Application No: CM/45/24/HH

Site Address: 2 Rose Cottages Climping Street Climping BN17 5RH

Description of works: Part single, part two storey side and single storey rear extensions. Creation of a drive following demolition of existing extensions.

Thank you for your internet representation made on 2nd January 2025 which has been recorded as an objection with the comments as follows:

DRAWING TITLE  
Proposed Floor Plans and Site Plan

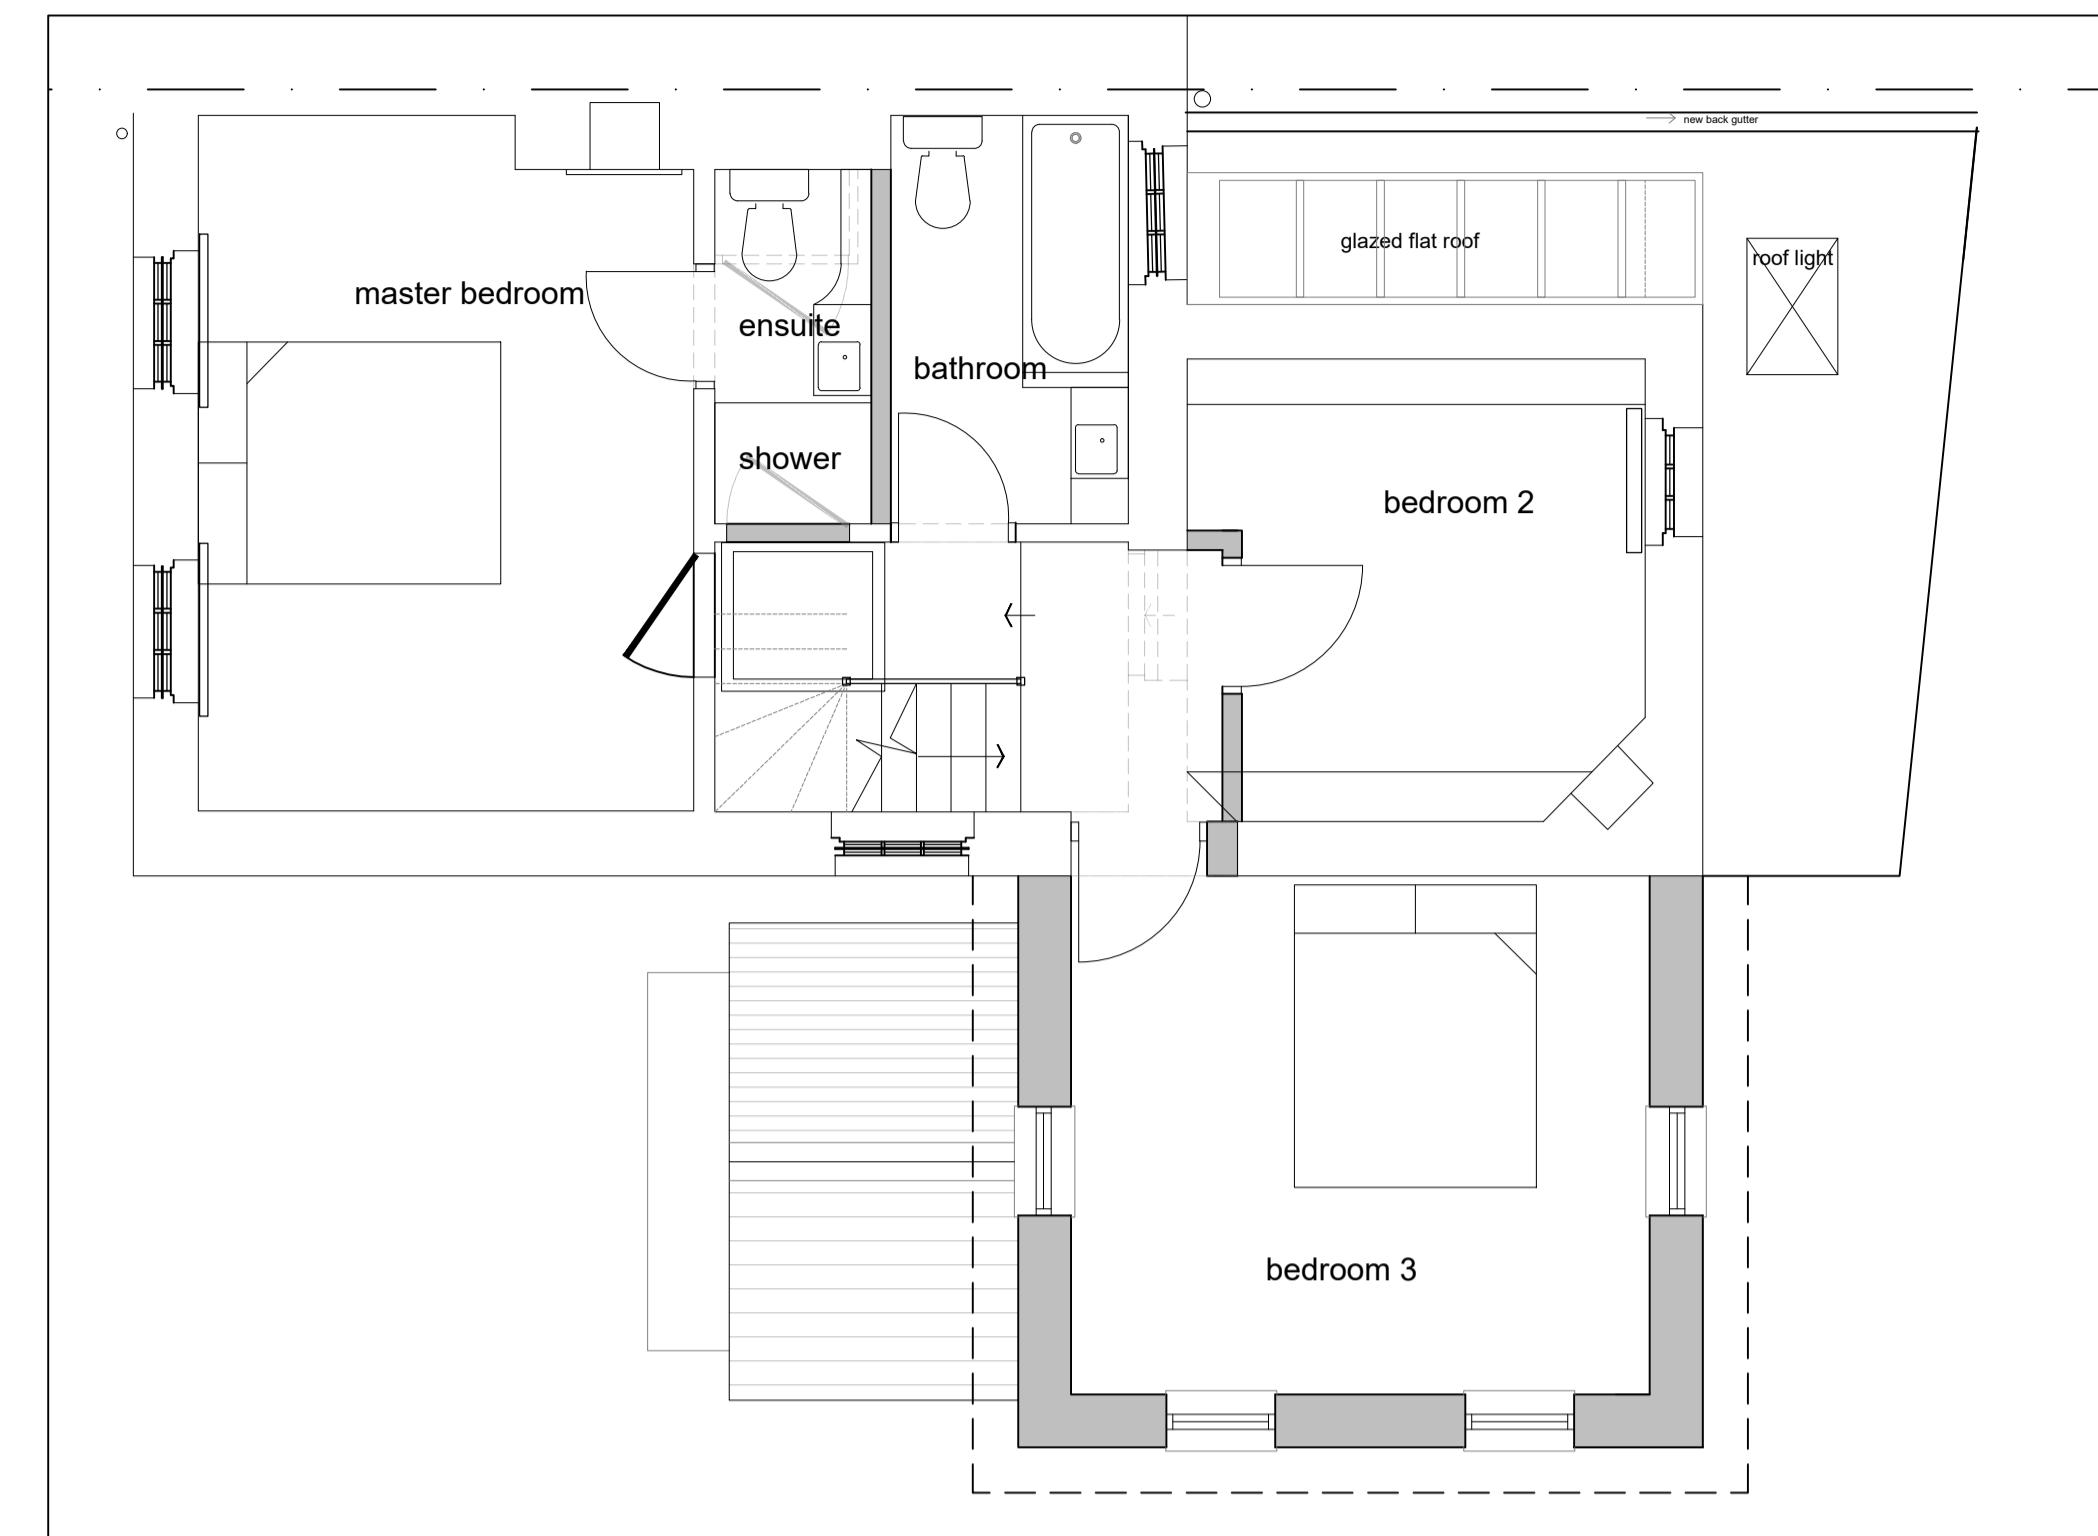
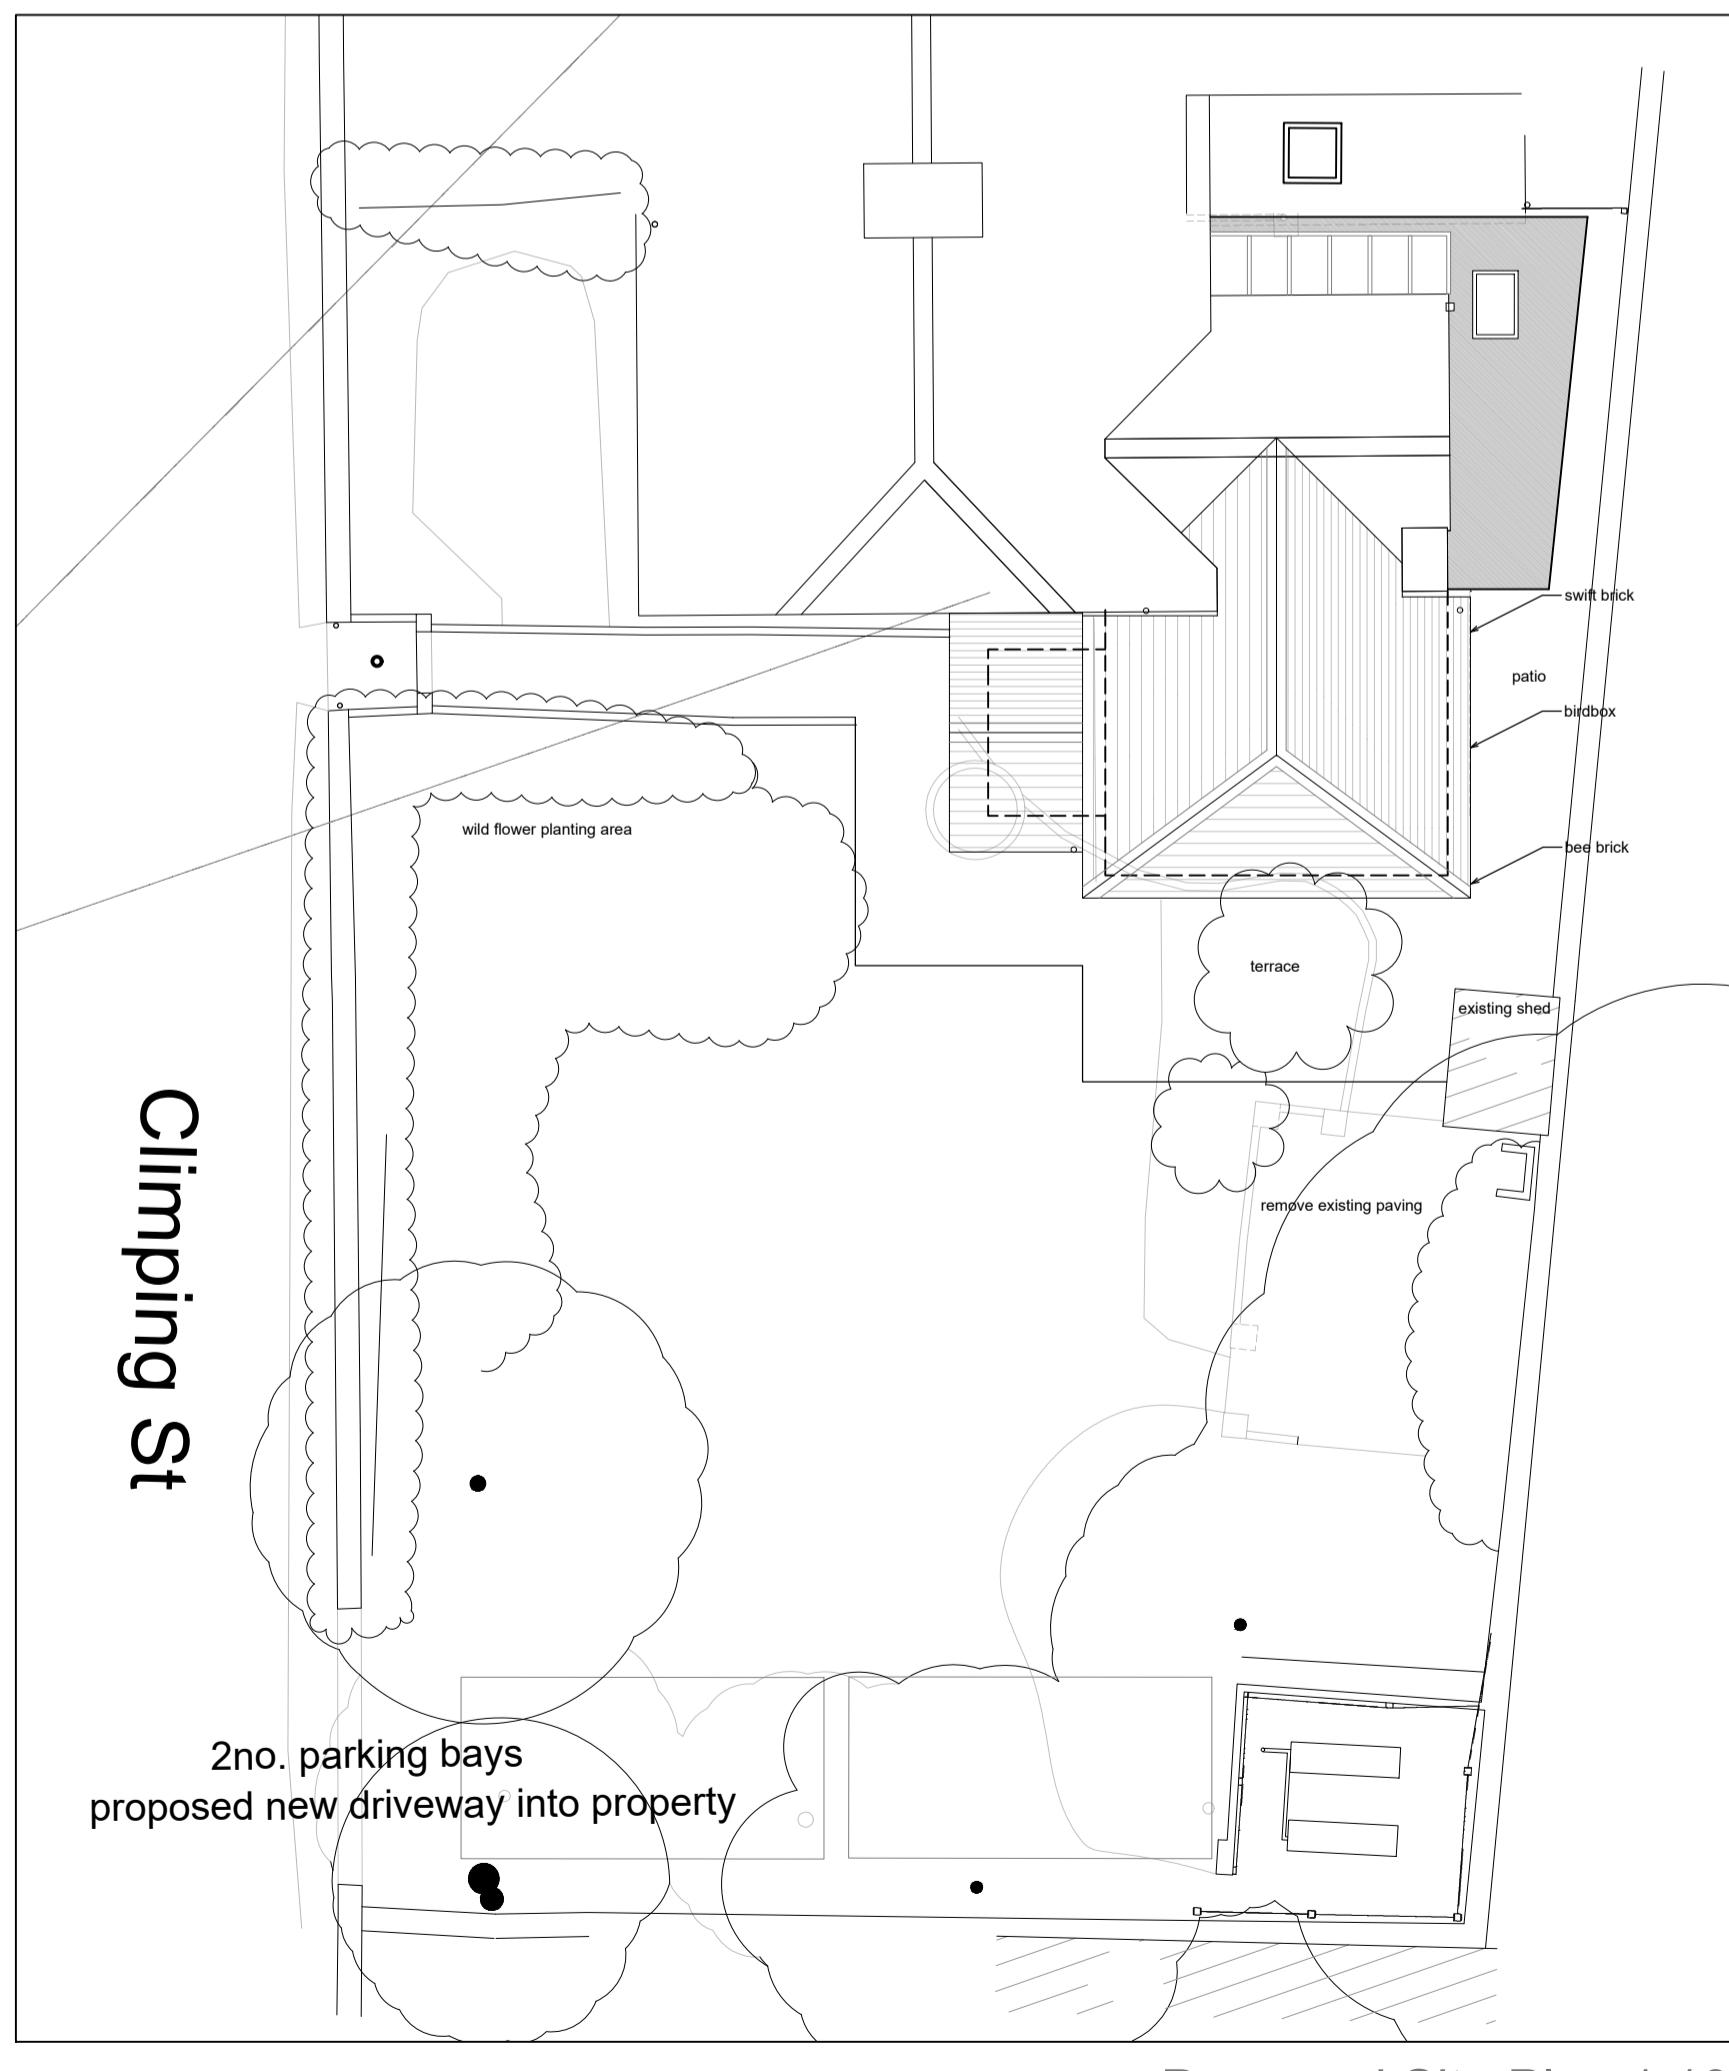
I own the adjoining semi-detached property 1 Rose Cottages. We built into the space at the rear of property and agreed a party wall with 2 Rose Cottages. Please may I see plans on how the proposed flat roof extension will join to my property as I have the following concerns:

1. what is the height of the proposed flat roof extension and how will it join to the pitch roof on my property. Will the height be underneath the eaves or the same level?
2. if higher how will water drain from the proposed flat roof?
3. There are waste pipes on the rear of 2 Rose Cottages that join with 1 Rose Cottages. How will they be incorporated into the proposed new extension
3. There is a joint sewer pipe that runs behind my property close to the boundary wall. We could not build close to the boundary wall so as not to build over this. Does the proposed flat roof extension build over the sewer pipe in 2 Rose Cottages?
